A14 Cambridge to Huntingdon improvement scheme

Statement of Common Ground between Highways England and Hilton Parish Council

Date: 28 September 2015

Reference: HE/A14/EX/98/PC11

Drawing title  
**ENGINEERING SECTIONS  
HILTON ROAD  
SHEET 16 OF 59  
REGULATIONS 5(2)(o) & (p) & 6(2)**

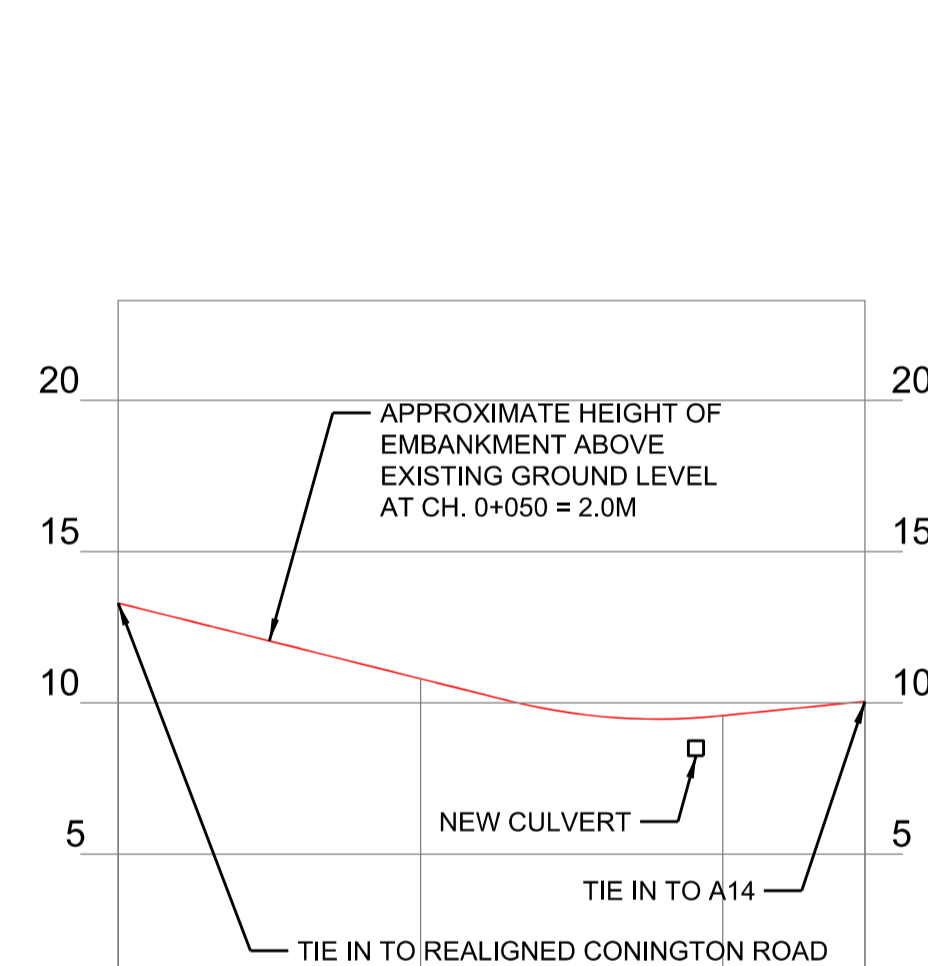
4	Design and Engineering Standards Height of overbridges	Clarification is required on actual height of bridges above existing ground level. The Potton Road and Hilton Road bridges appear to be up to 2	There is scope for refinement at detailed design stage when exact structural options are determined. There will be opportunity for consultation	Under discussion.

<p>metres higher than what is actually required with Potton Road at 11m; and Hilton Road bridge at 10.7m. More detailed engineering drawings are required and engagement at the detailed design stage.</p> <p>Highways England subsequently stated the additional height is due to the single span of the bridge across all six lanes with no central support.</p>	<p>and engagement during detailed design stage, at which stage there will be opportunities to comment on designs.</p> <p>At detailed design the elevation of side roads crossings will be minimised to reduce both impacts and costs. Please refer to Appendix B.</p> <p>In the meantime we will continue to discuss the height and appearance of structures with you.</p>	
5	Landscape and visual effects	<p>Concerns regarding the visual impact and appearance of structures along the route.</p> <p>Hilton Parish Council request to get the best mitigation possible for the people of Hilton.</p> <p>Hilton Parish Council also questions the rules and guidelines which Highways England contractors will have to work to.</p> <p>Hilton Parish Council are concerned about the impact of light pollution from high sided vehicles hence the wish for a higher barrier up to 4m in height.</p>	<p>In view of the concerns raised about visual impacts as the road passes Hilton (in particular relating to the Potton Road over bridge), a desk study has been undertaken to identify a proposed additional and representative viewpoint on the north edge of the village which places the overbridge clearly in view without intervening screening. It is to show the proposed scheme and the Potton Road bridge before construction and at year 1 and year 15 after construction.</p> <p>This viewpoint was shared with Hilton Parish Council and a site meeting was held with the Parish Council on 3 June 2015 to assess the suitability of this and potential alternative viewpoints suggested by the Parish Council. The Parish Council concurred that Highways England's proposed viewpoint is suitable for an additional photomontage.</p> <p>The photomontages from the agreed viewpoint can be found within Highways England's Response to the First Written Questions</p>	Under discussion.

As set out in Highways England’s response to the First Written Questions, Question 1.9.9, the majority of the new bridge structures on the scheme, including those on the Huntingdon Southern bypass section, are similar in nature and have been developed as a family of structures known as the ‘Standard Overbridges’.

Preliminary design of this family of structures has been carried out with key consideration to the impact on the landscape, which is predominantly flat and open rural in nature. Solutions with ‘open abutments’, with small bankseat abutments, allowing the slopes of the approach earthworks to extend below the bridge deck, have been preferred as they are less visually obtrusive. A three span arrangement has been chosen as this is more visually appealing and avoids maintenance issues with a two span arrangement with pier in the A14 central reserve.

At detailed design the elevation of side roads crossings will be minimised to reduce both impacts and costs.

The typical height of an overbridge is 11.2 metres above ground level, this height is a summation of the following requirements:

1. The height of the mainline above ground level is driven by drainage requirements;
2. A 5.3 - 5.7 metre headroom is required under the bridge to accord with design standards (this depends on the structures impact resistance, so the scheme uses 5.7 metre structure to keep structure options open);
3. A structural depth of 2.0 metres is typically required (dependent upon the structure type and span);
4. Allowance for construction on bridge;
5. Allowances for road crossfall, gradient, construction and settlement etc.

- $3\text{m} + 5.7\text{m} + 2\text{m} + 0.5\text{m} = 11.2\text{ metres above ground level.}$
